PINE VIEW ESTATES FILING NO. 1 PRELIMINARY PLAN

SECTION 13, TWP 11, RANGE 64 WEST OF 6TH PRINCIPLE MERIDIAN
EL PASO COUNTY, COLORADO

PCD FILE NO: SP-20-004

PINE VIEW ESTATES FILING NO. 1

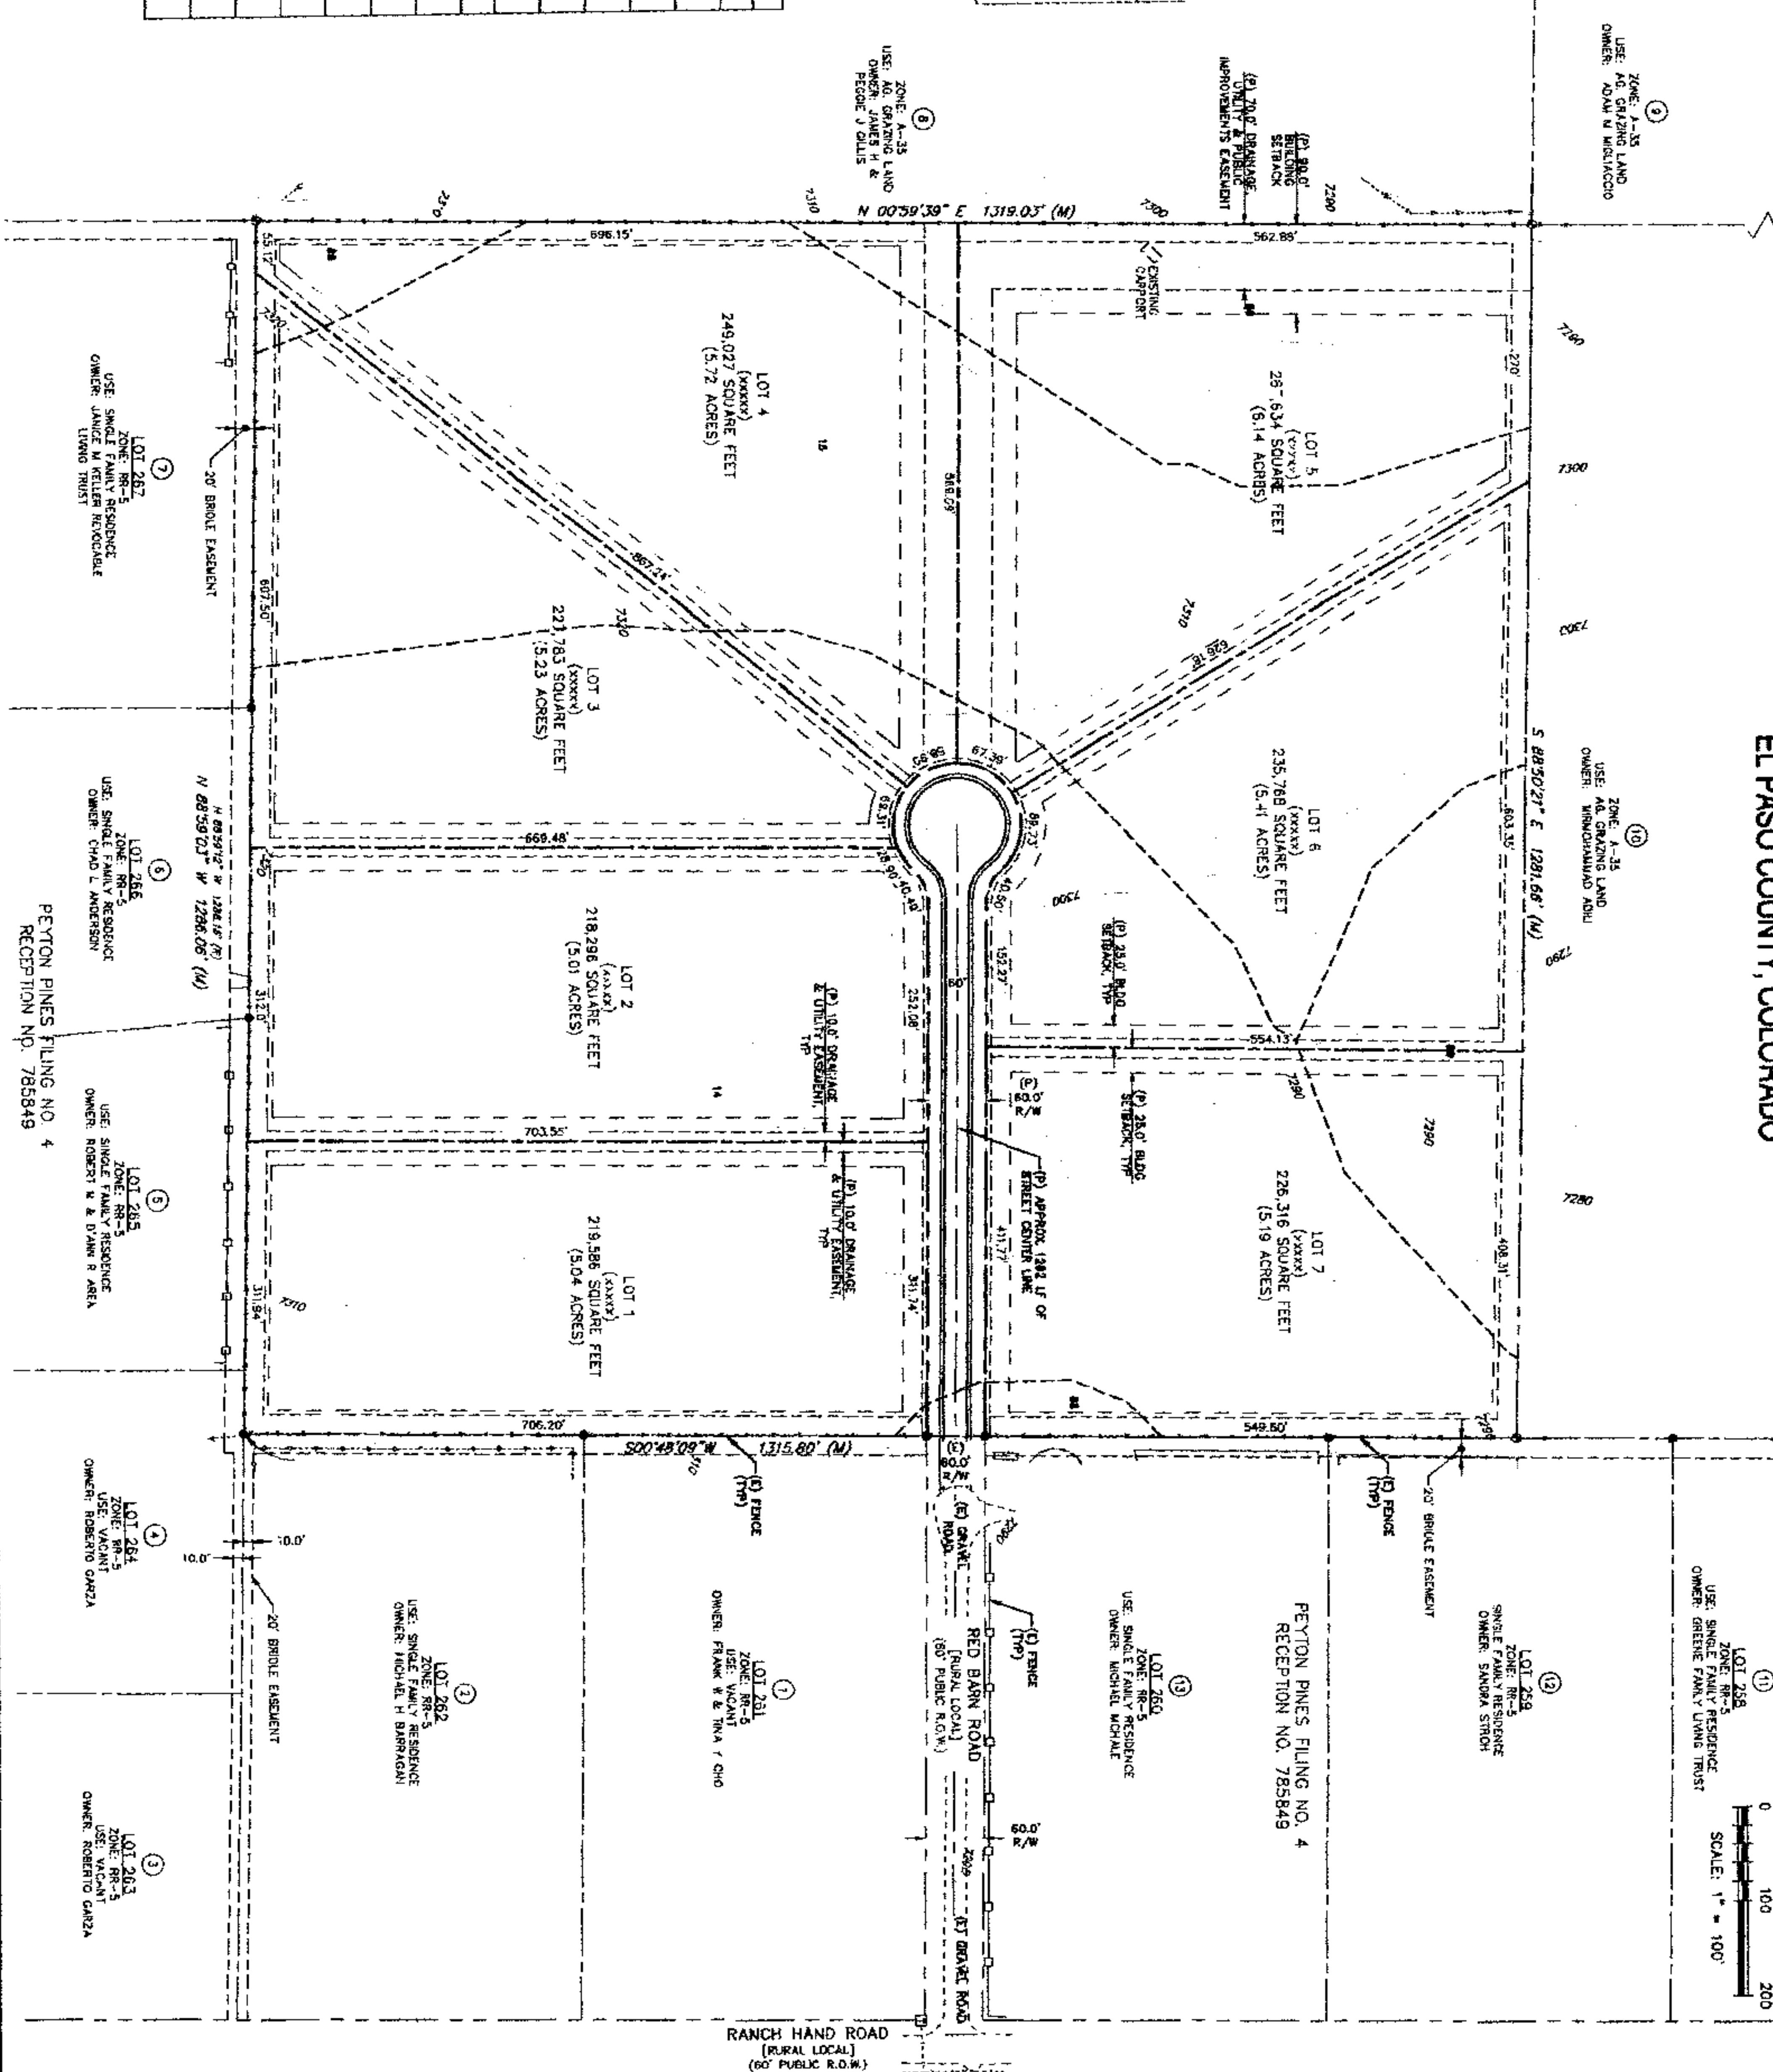
After staffs discussion with the County Attorney and with other engineering staff, the connections to the west and north should just be indicated as public ROW similar to what is done for red barn road. Please adjust the property lines for lots 3 & 4 accordingly. Please feel free to call me (719-208-6783) if you'd like to discuss.

Please clarify the significance of the soil area boundaries. Are these hazard areas that should be on the plat also? Also staff suggests using a different line type as it is very similar to the easement line type.

Review I comment: Identify what the interior black line is at the proposed roadway.

Review II comment: Please label the road edge. Unresolved.
